**Consultation Response from KC,
Highways Development Management****2025/93182 Builders yard, Meltham Road, Honley, Holmfirth, HD9 6RT****Demolition of existing building and erection of one dwelling****Date Responded: 20-01-2026****Responding Officer: D. Stainsby****Responding Ref: K3-31/7****RECOMMENDATION:**

FLOOR PLAN

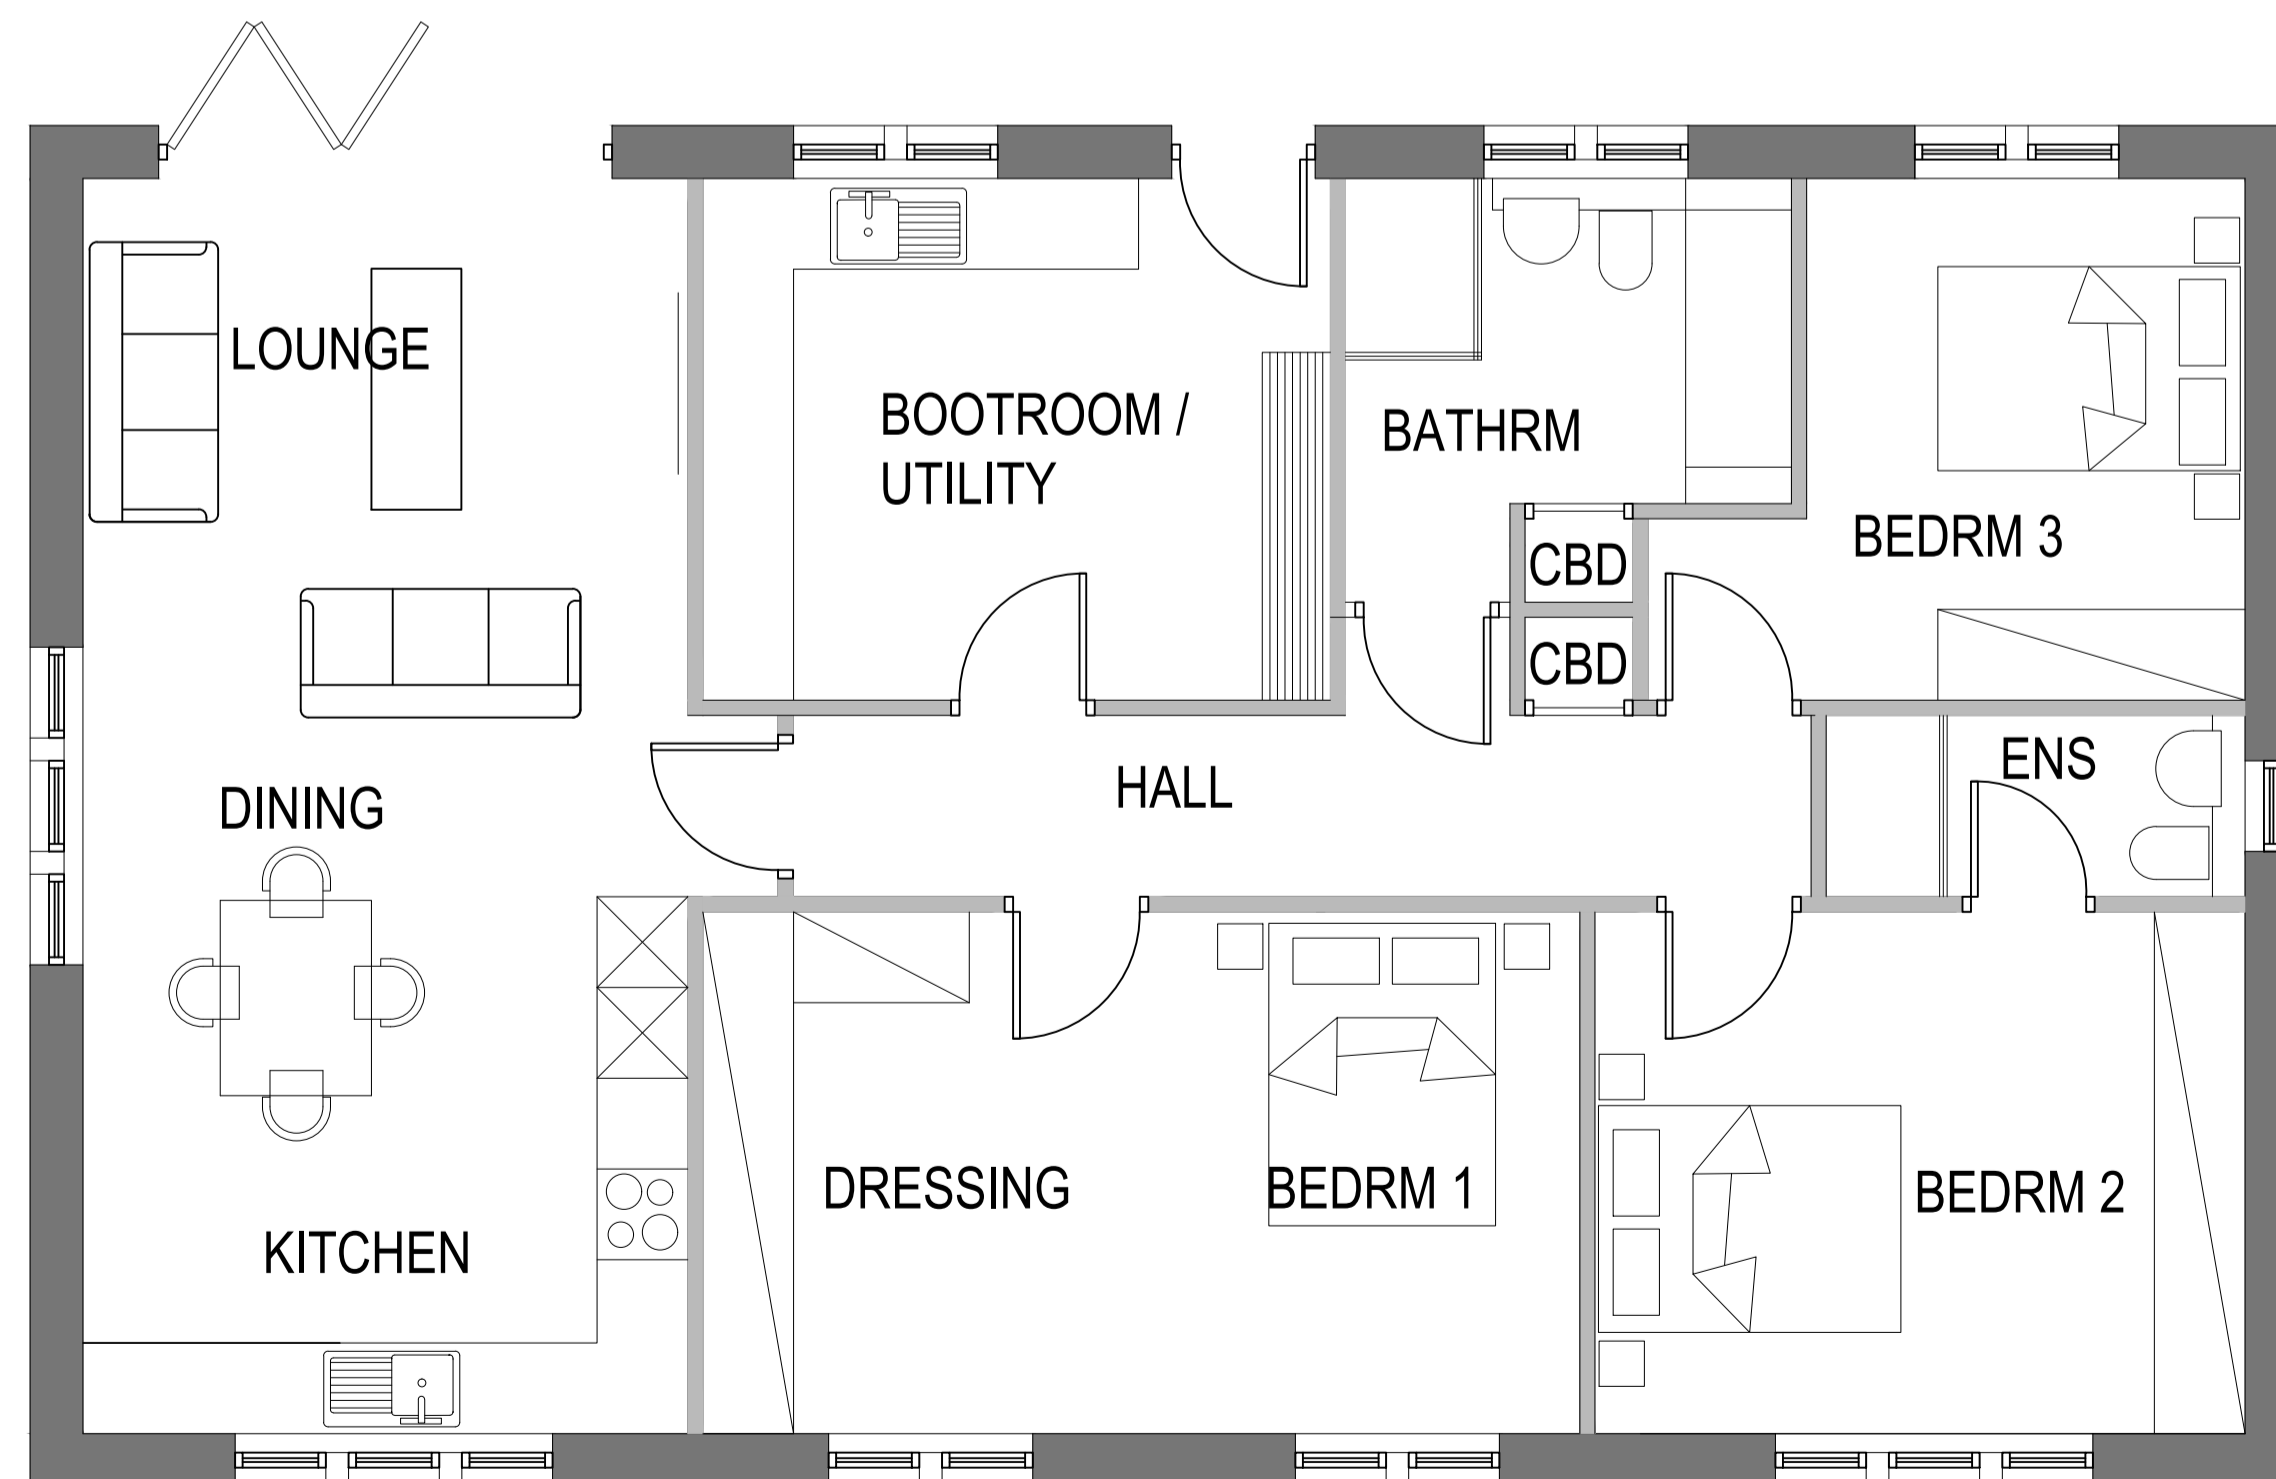
Parking for 3 cars have been provided, together with internal turning enabling vehicle to enter and egress the site in forward gear.

The internal layout is acceptable.

A bin storage area is shown within the site. However, this is set back approximately 20m from the adopted highway.

A bin collection/presentation point should be located adjacent to the public highway. The bin collection/presentation point must not obstruct the adopted highway or the access road.
